From: Katie Kurek [REDACTED]
Sent: 29 June 2018 13:33
To: Planning.Responses
Cc: Jacky Pendleton
Subject: RE: Planning Consultation on: Y/47/18/PL

TO:	Arun District Council FAO: S Davis
FROM:	Highways, WSCC
DATE:	29 th June 2018
LOCATION:	Land adjacent 1 - Holkham Cottages, Burndell Road, Yapton, BN18 0HP
SUBJECT:	Y/47/18/PL erection of 2 no. dwellings.
RECOMMENDATION:	ADVICE
\$106 CONTRIBUTION TOTAL:	£N/A

West Sussex County Council, as the Local Highway Authority (LHA), has been consulted on proposals for 2 x 2-bedroom dwellings on land east of no. 1 Holkham Cottages.

DRAWING TITLE
Proposed Site Plan
Location and Block Plans

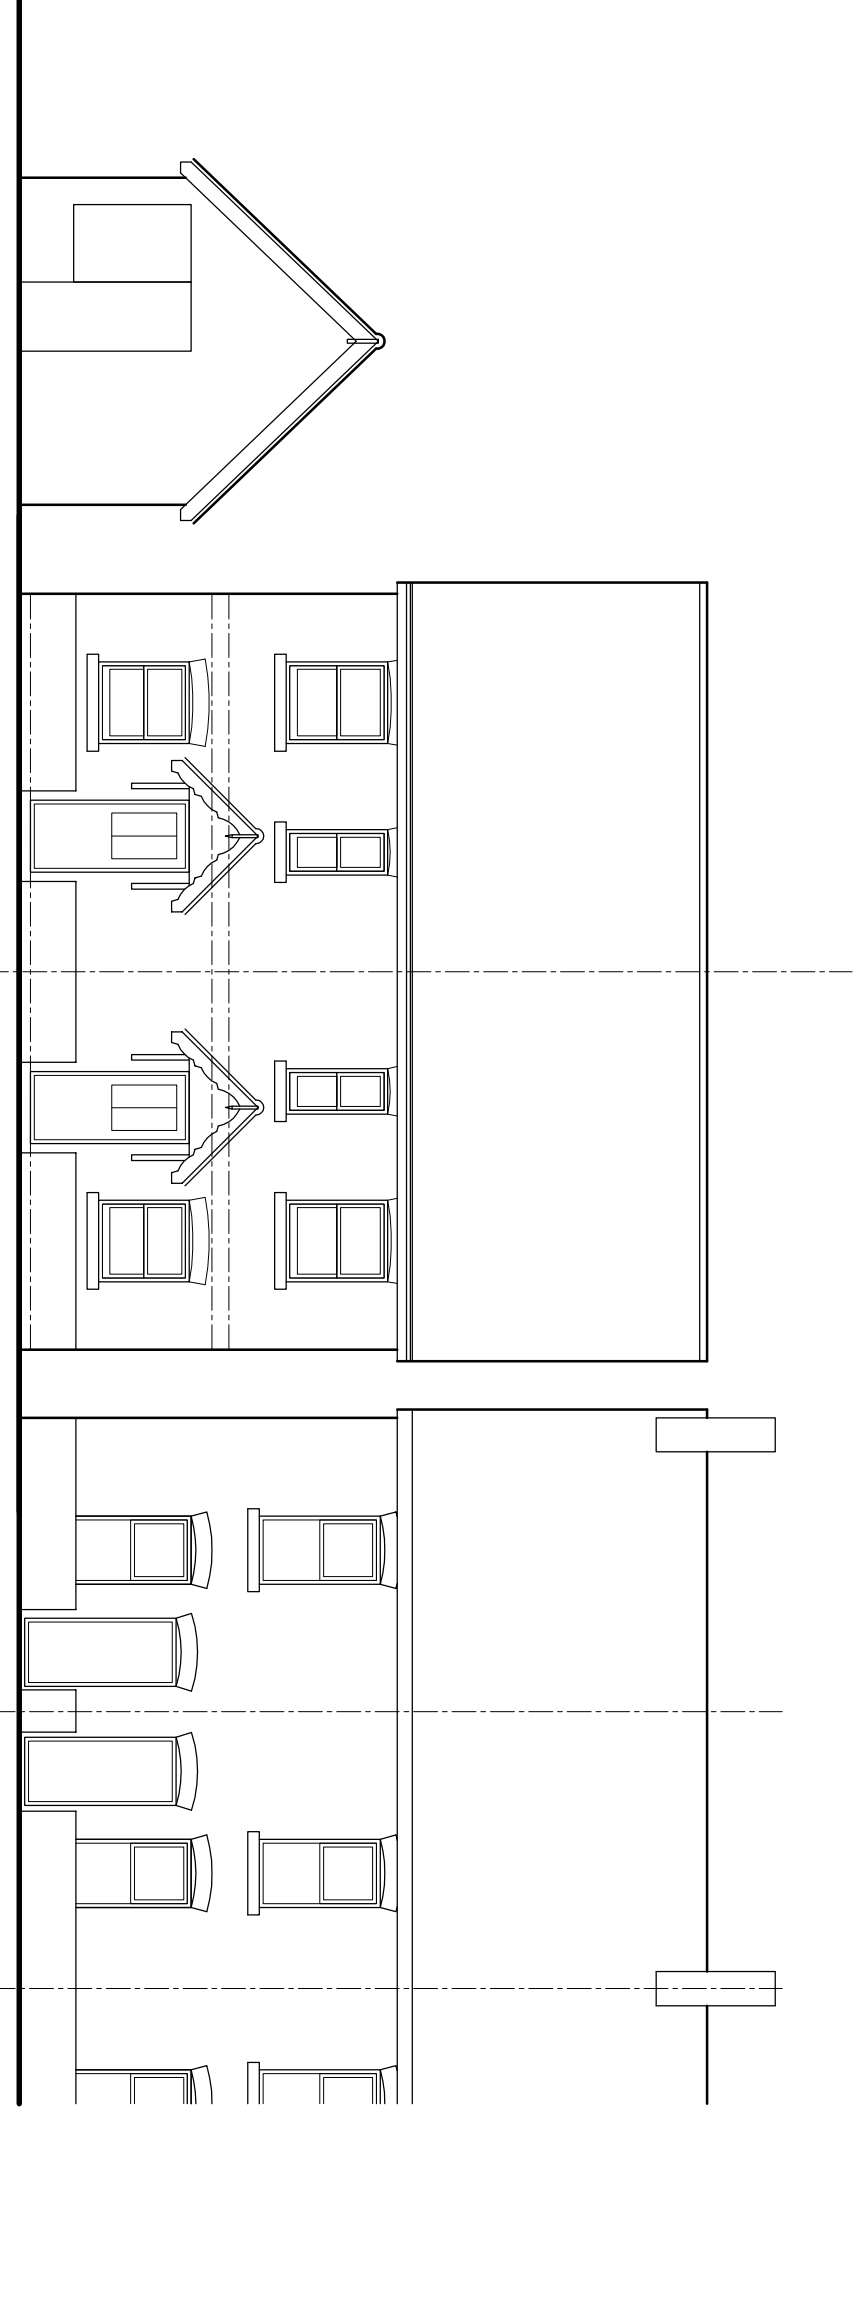
Burndell Road is 'B' classified district distributor road subject to a 30mph speed restriction in this location. The 2 x dwellings will continue the building line of the existing terraced properties. I note from local mapping that a vehicle crossover currently in place adjacent the host property. This should be closed up and the footway reinstated.

No part of the development shall be first occupied until covered and secure cycle parking spaces have been provided in accordance with plans and details submitted to and approved by the Local Planning Authority.
